**KIRKLEES COUNCIL  
TOWN AND COUNTRY PLANNING ACT 1990  
HIGHWAYS DEVELOPMENT MANAGEMENT**

**PLANNING REF** 2018/62/91661/E0/GW  
**CATEGORY** Small Major

**PROPOSAL** OUTLINE PERMISSION FOR RESIDENTIAL DEVELOPMENT AND FACILITATING ENGINEERING OPERATIONS AND FULL PLANNING PERMISSION FOR ACCESS AND SPINE ROAD

**LOCATION** LAND AT WALKLEY TERRACE AND BRUNSWICK STREET, HECKMONDWIKE

| Drawing Title:  | SITE PLAN - OPTION 4 AS PROPOSED                                 |

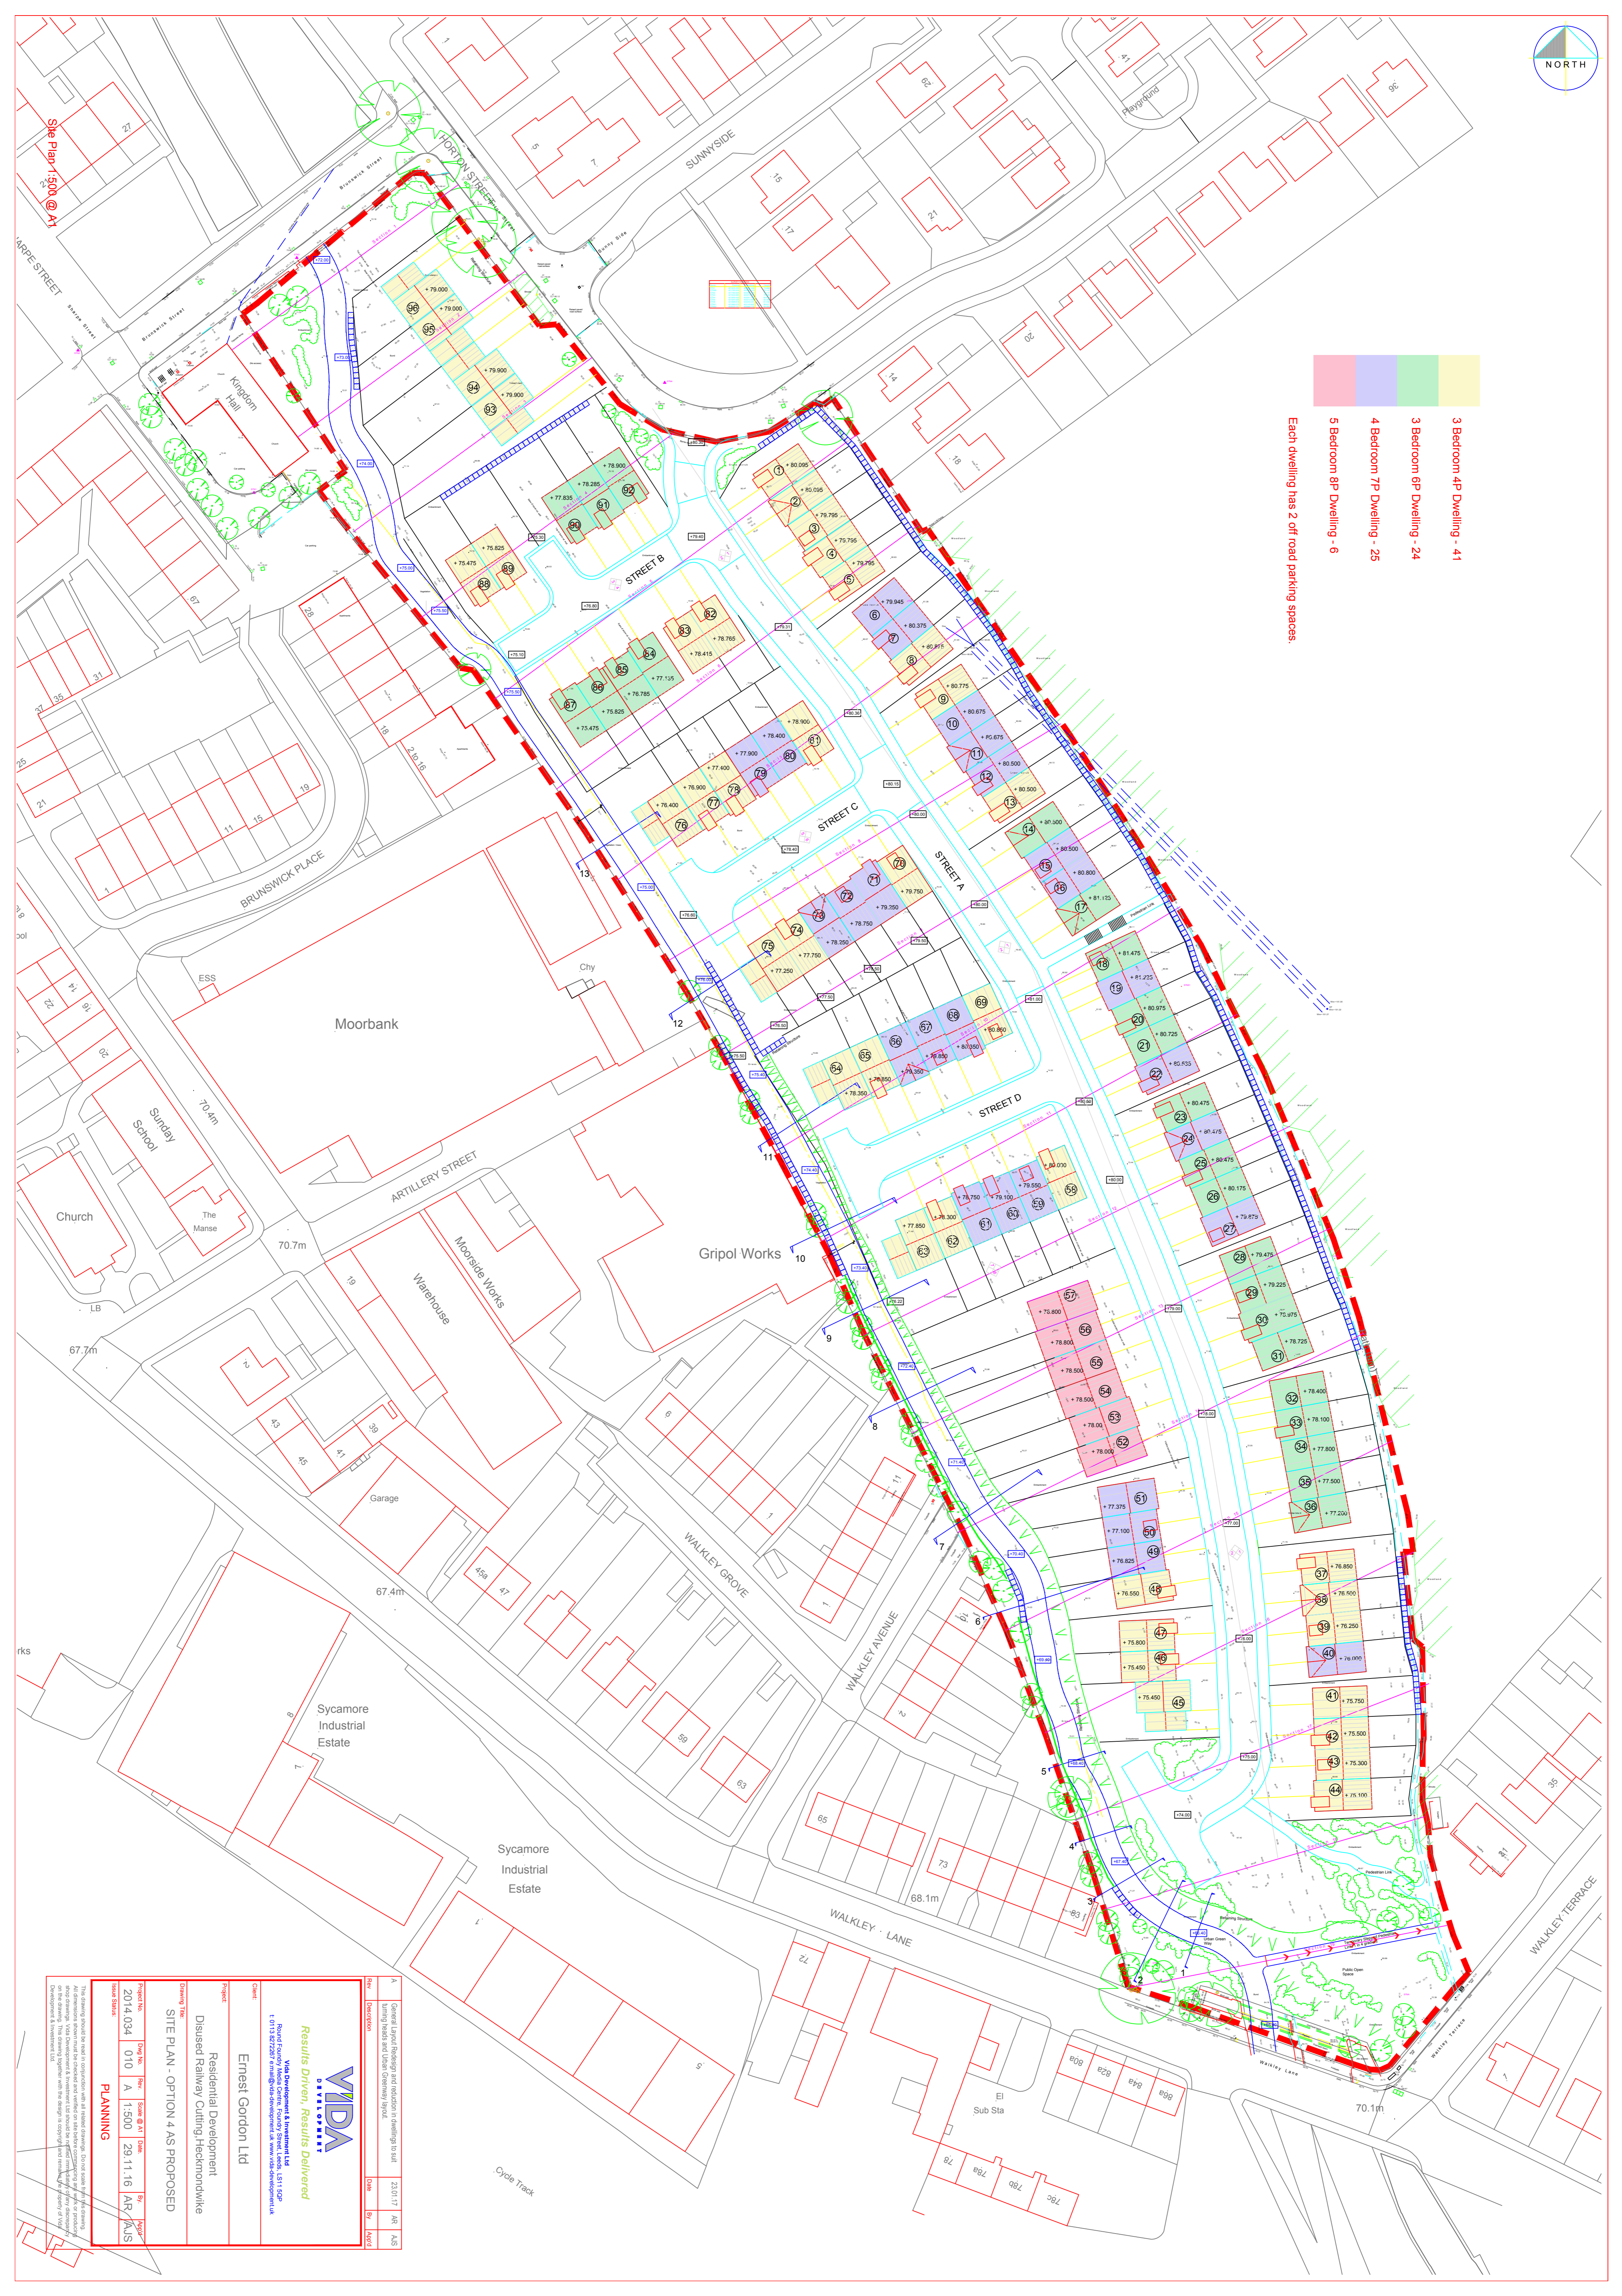
1,The proposed shared surface carriageway serving the proposed housing is relatively long and straight for a road of this type and with a carriageway width of 5.5m this road layout is unlikely to result in a design speed of 15mph. This type of road layout should be angular with alignment shifts. Consideration should be given to the provision of a footway to one side and redesign to include a restriction points. Footways should be 2.0m in width.

5,The proposed visitor parking spaces are not well spaced along the length of the proposed road. They are also insufficient in size and the splays are insufficient. Visitor parking bays should be 6.0m at the rear with 30 degree splays.

6, It is proposed to provide 2 off-street parking spaces per dwelling which is only acceptable if the proposed dwellings have 3 or less bedrooms. Larger dwellings will require 3 off-street parking spaces.

8, No house types are provided and the parking strategy needs to be clarified.

9, Bin presentation points should be shown to be provided to each dwelling. These should be sited to allow bins to be presented without obstructing the highway or the access to driveways.

10, The footway shown between the site access and Brunswick Street to be dependent upon future planning consent should be included as part of the proposals for this site.

11, There is no pedestrian link to Wesley Terrace

Drawing No.
SK04

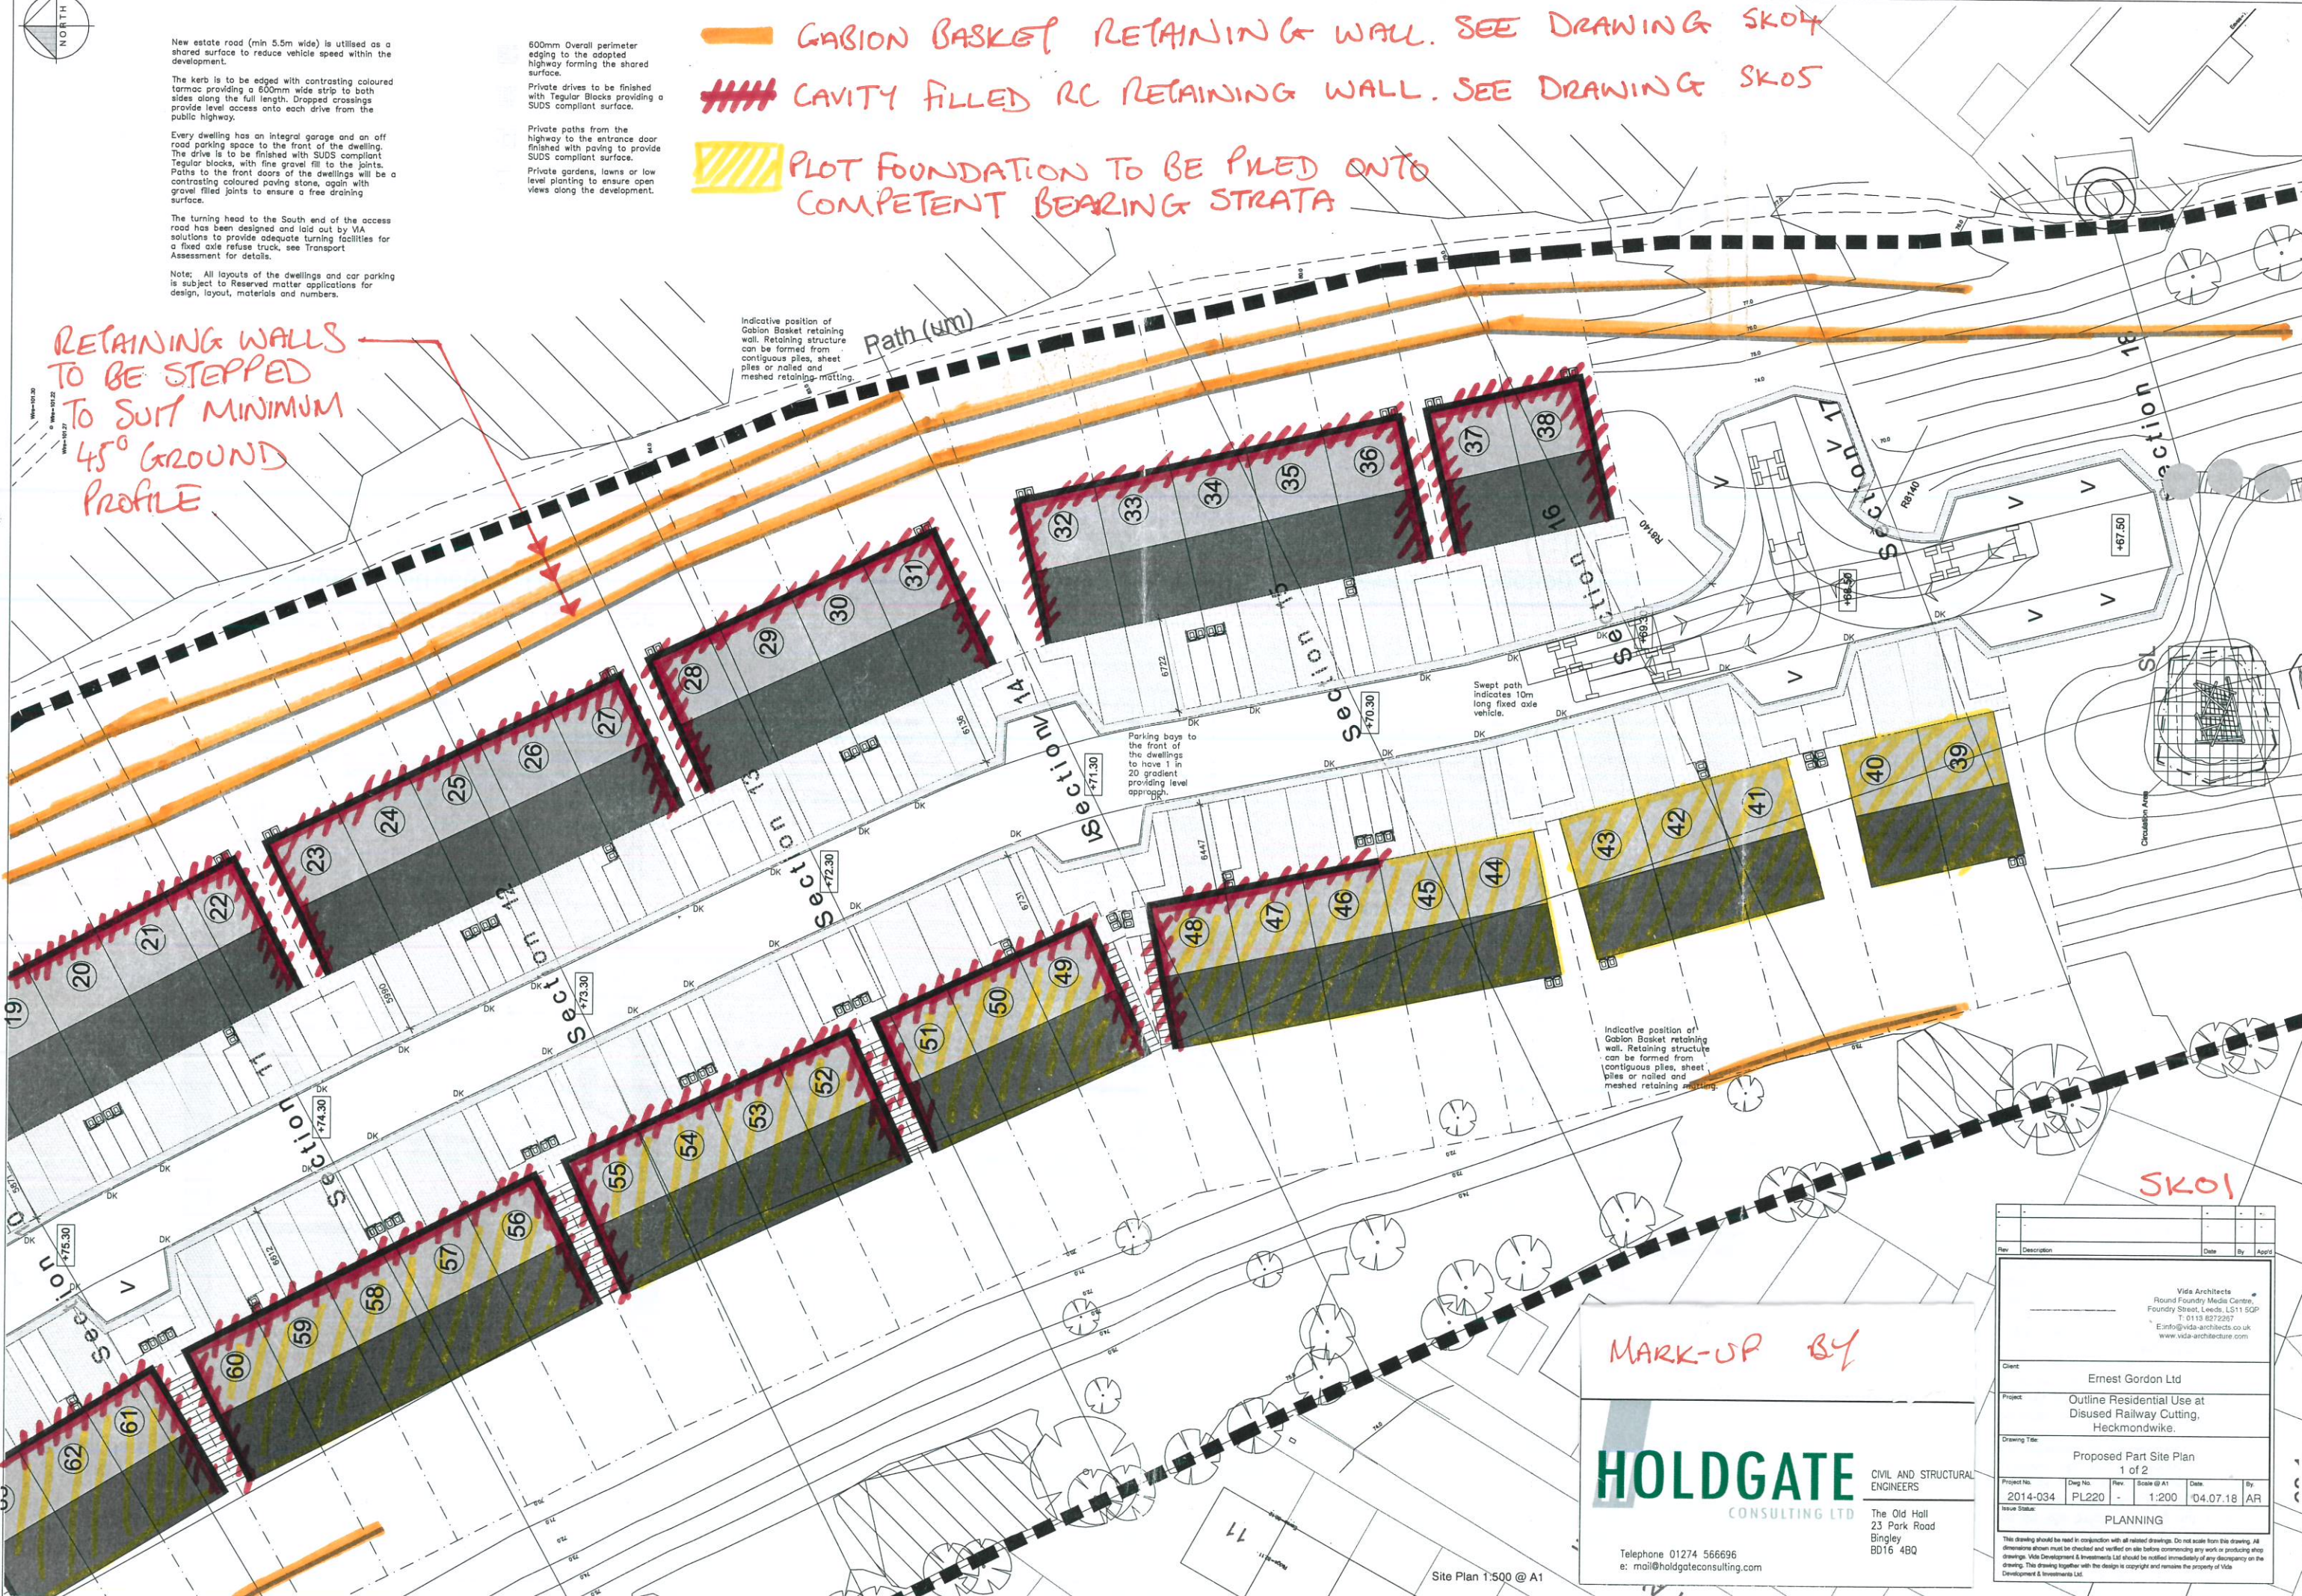
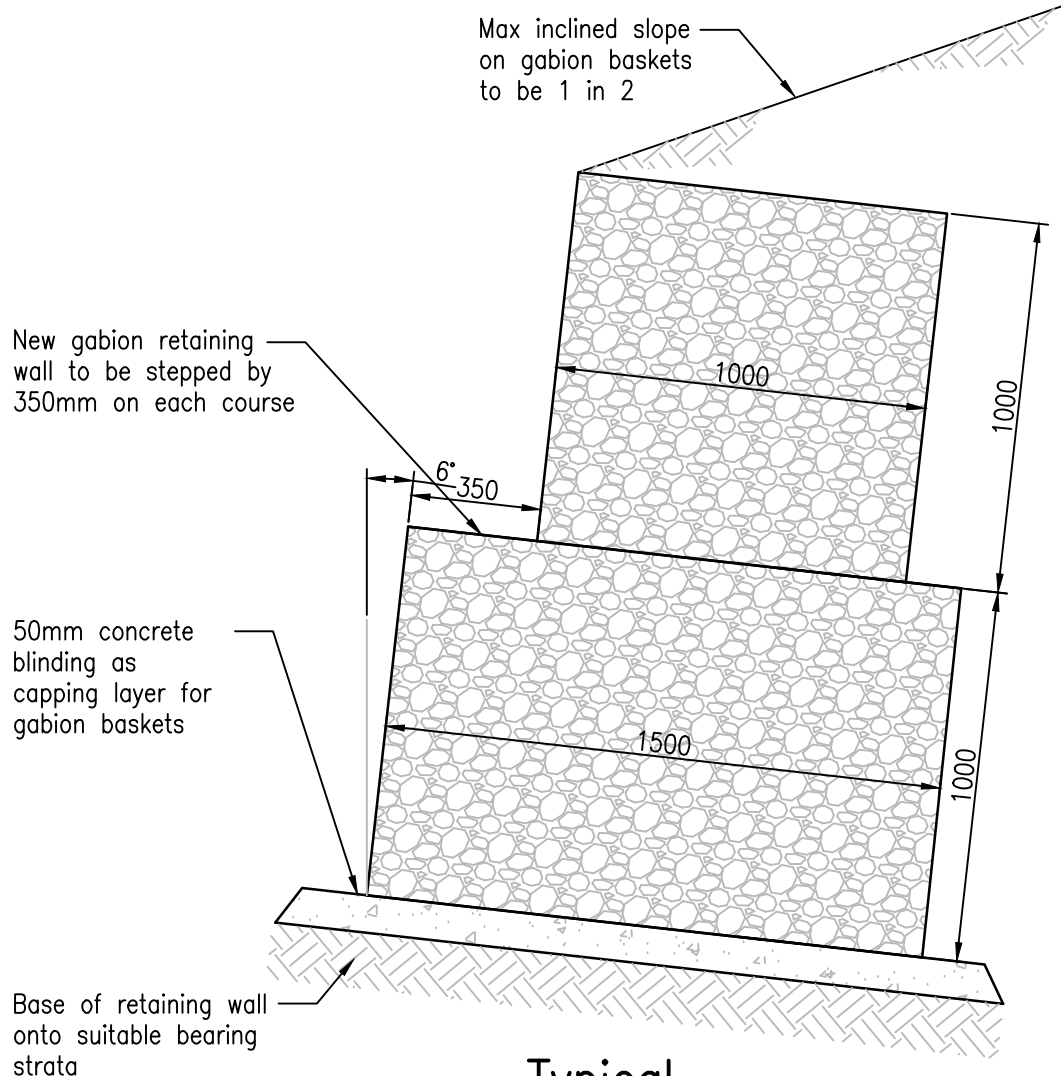
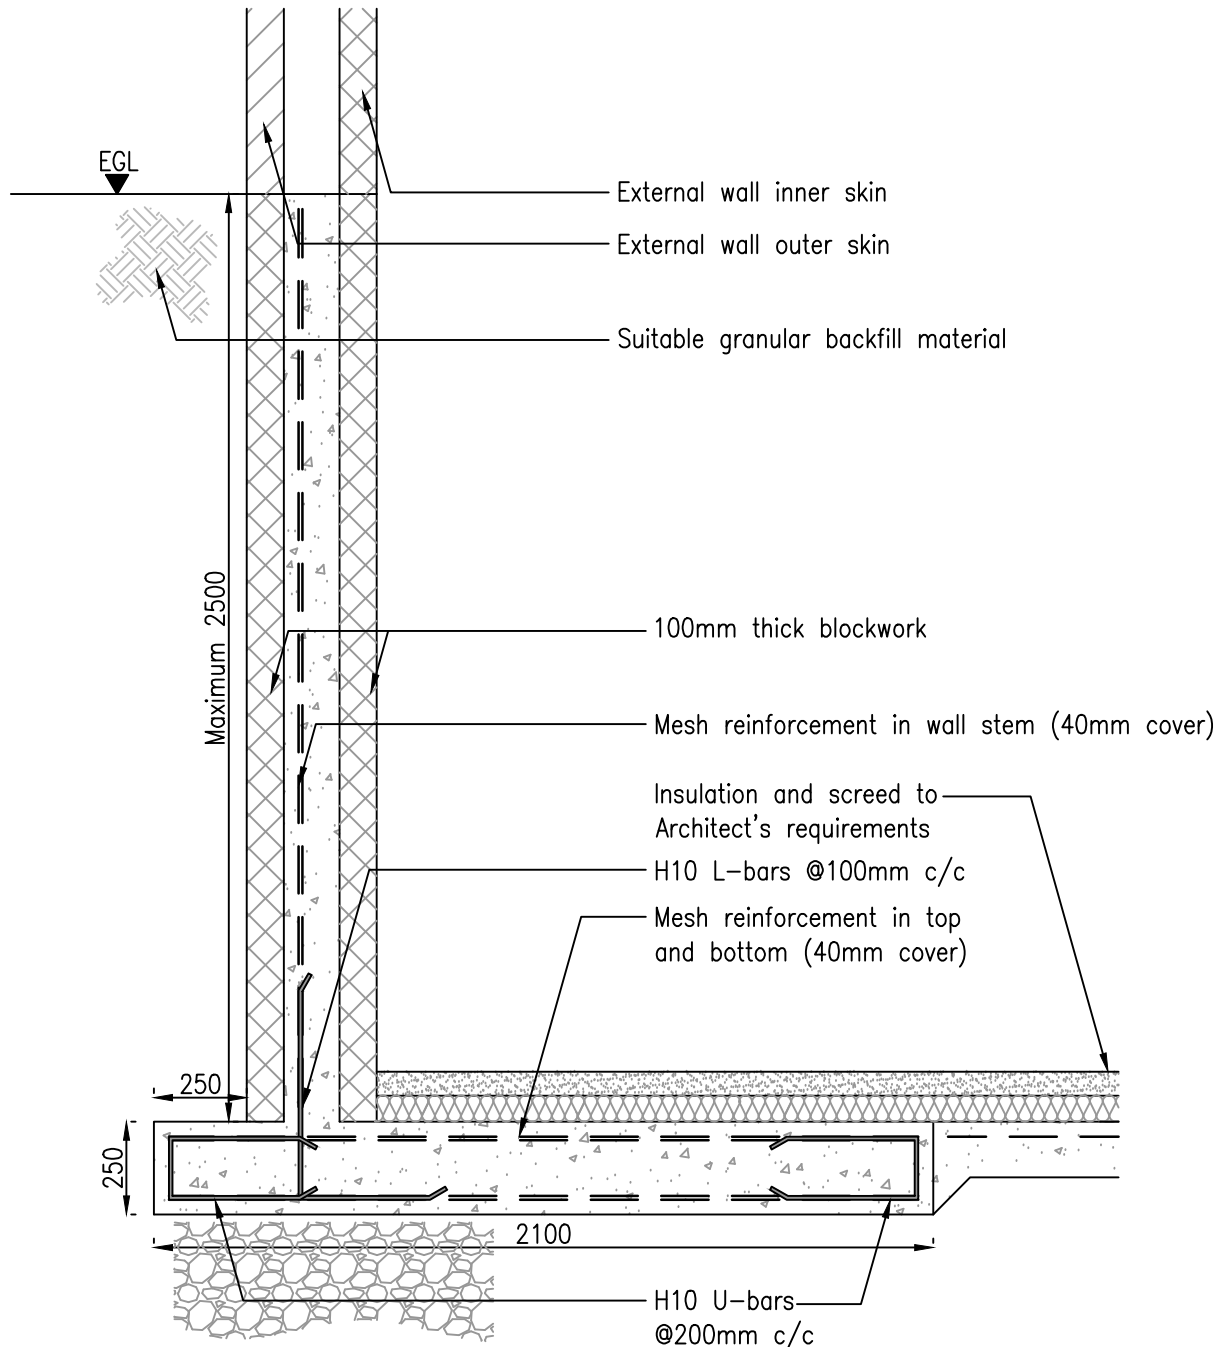
1, The steep slope immediately adjacent to the visitor parking is unacceptable. Similarly the retaining wall proposal is unacceptable.

3, Any retaining features affecting the highway will require formal technical approval by the Council as the Highway Authority. I would recommend providing details of all proposed retaining features and underground storage facilities (including pipes) to my colleague Farhad Khatibi (Team Leader) in the structures section at the earliest opportunity, who will be able to advise you of the necessary requirements in more detail.
